The Sizewell C Project

Natural England's Comments on the Outline Vessel Management Plan

Planning Inspectorate Reference: EN010012

3rd September 2021

Plate 4.2: Indicative Delivery Routes – Local Ports

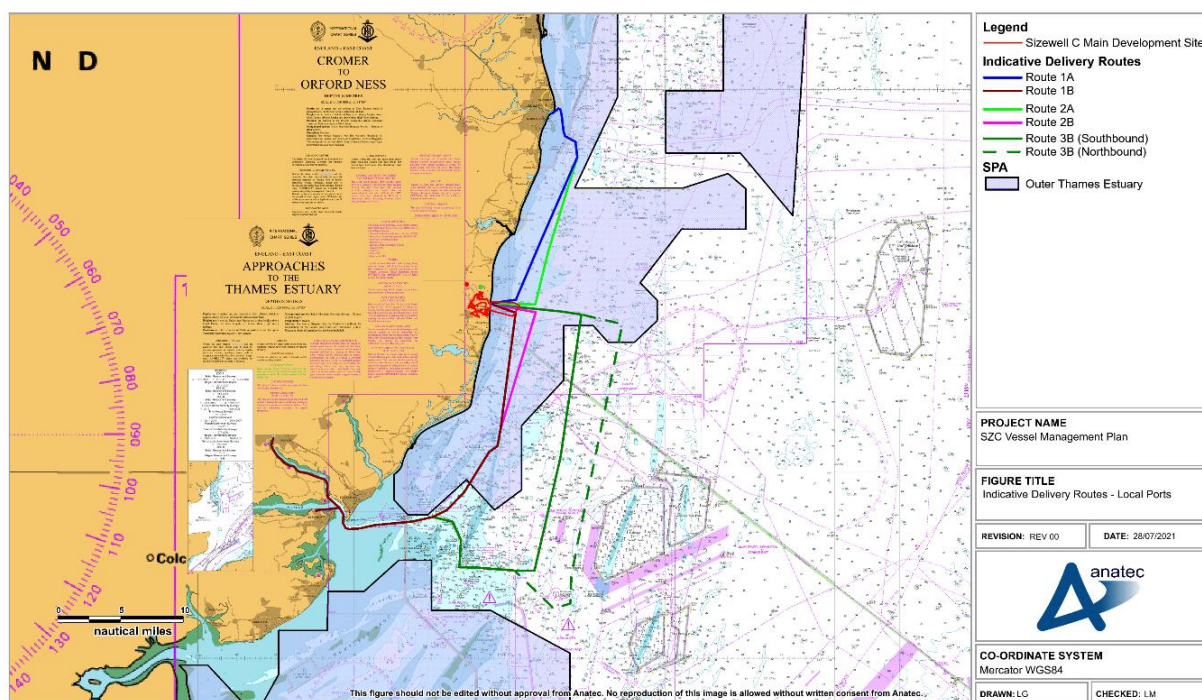
4.1.7 (Plate 4.2)	We do not consider the use of Route 1A or 1B to be appropriate as it is novel, situated farther inshore, and is likely to cause red-throated diver disturbance alone, and in-combination (cumulatively) with the nearby route that is already established. Route 2A (for Lowestoft) appears to be a suitable compromise as it follows an existing route, albeit still almost entirely within the OTE SPA, it is likely that red-throated divers are already displaced from this route area. Route 3B (for Ipswich/Harwich) would be preferred to reduce impacts on the OTE SPA.
Table 4.2	The percentage uplift figures presented in this table are erroneous and misleading. Annual (existing) vessel movements are used to calculate seasonal uplift. For route 2 a 233% uplift in vessel traffic is presented in the table for the winter period. In fact, if vessel movements only over the winter period are considered the uplift generated by 400 movements is much greater ($[172/12] * 5 = 71.67$ movements) $(400/71.67) * 100 = 558\%$ uplift in vessel traffic over the winter period

Plate 4.3: Indicative Delivery Routes – Isle of Grain

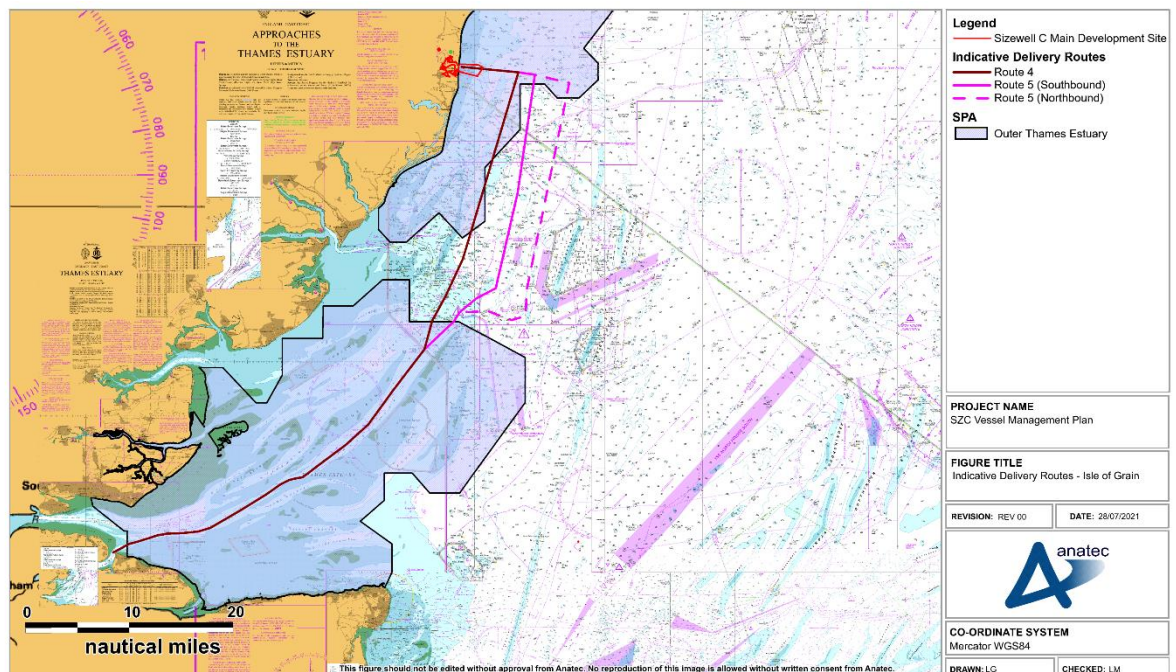
4.1.10	While the use of an existing shipping route (4) is preferable to a novel route, project impacts would ideally be further reduced by employing route 5 to reduce vessel time spent in the OTE SPA
Plate 4.4	Route 6 could be improved by entering the OTE SPA further to the south at the closest point at the boundary to SZC , thus reducing the amount of vessel time spent in the SPA.
